**REQUEST**

Current Zoning: N1-B (Neighborhood 1-B)  
Proposed Zoning: N2-A(CD) (Neighborhood 2-A, Conditional)

Approximately 4.1 acres located on the east side of South Tryon Street, west of Nations Ford Road, and north of Queen Anne Road.

The petition proposes to develop a vacant, wooded property in the S Tryon Street corridor with a community of up to 50 multi-family attached dwellings.

RZ-1.0

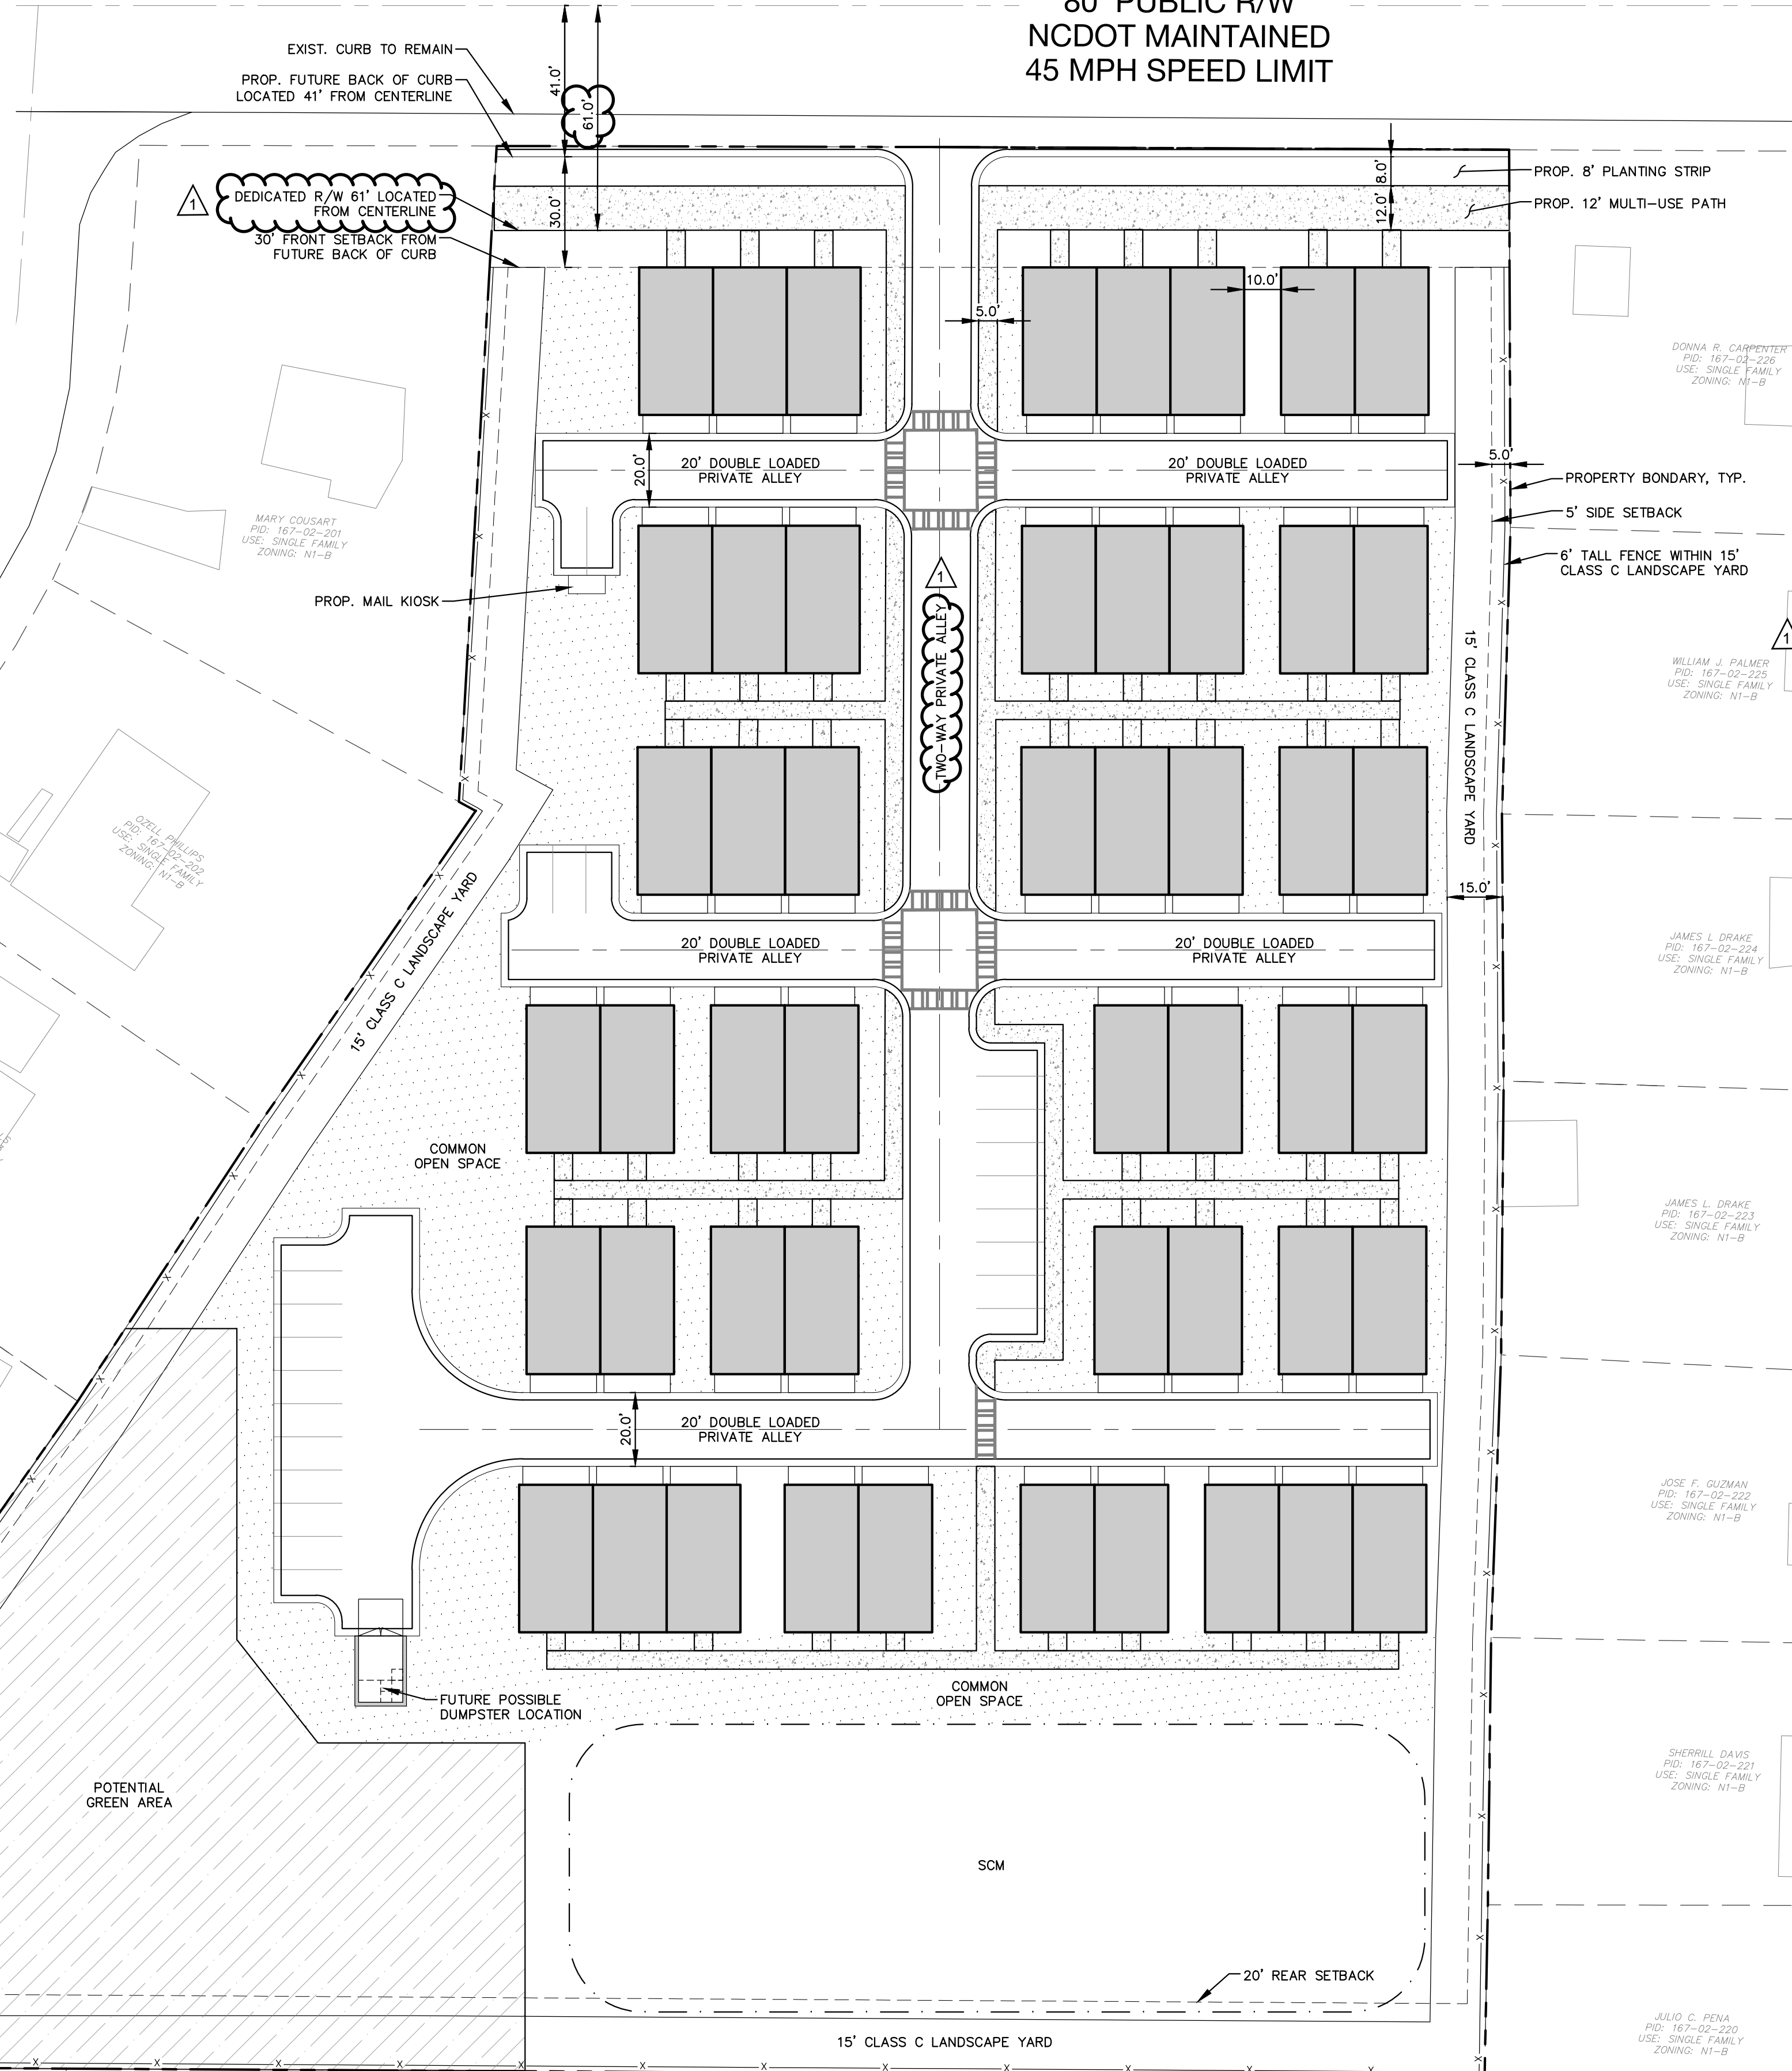
- ~~1. In coordination with NCDOT, revise site plan and conditional notes to install a right turn lane into the site with 50' of storage. ADDRESSED~~
- ~~2. Use only one line to show future back of curb. Move the driveway cut and curb and gutter to the existing location. ADDRESSED~~
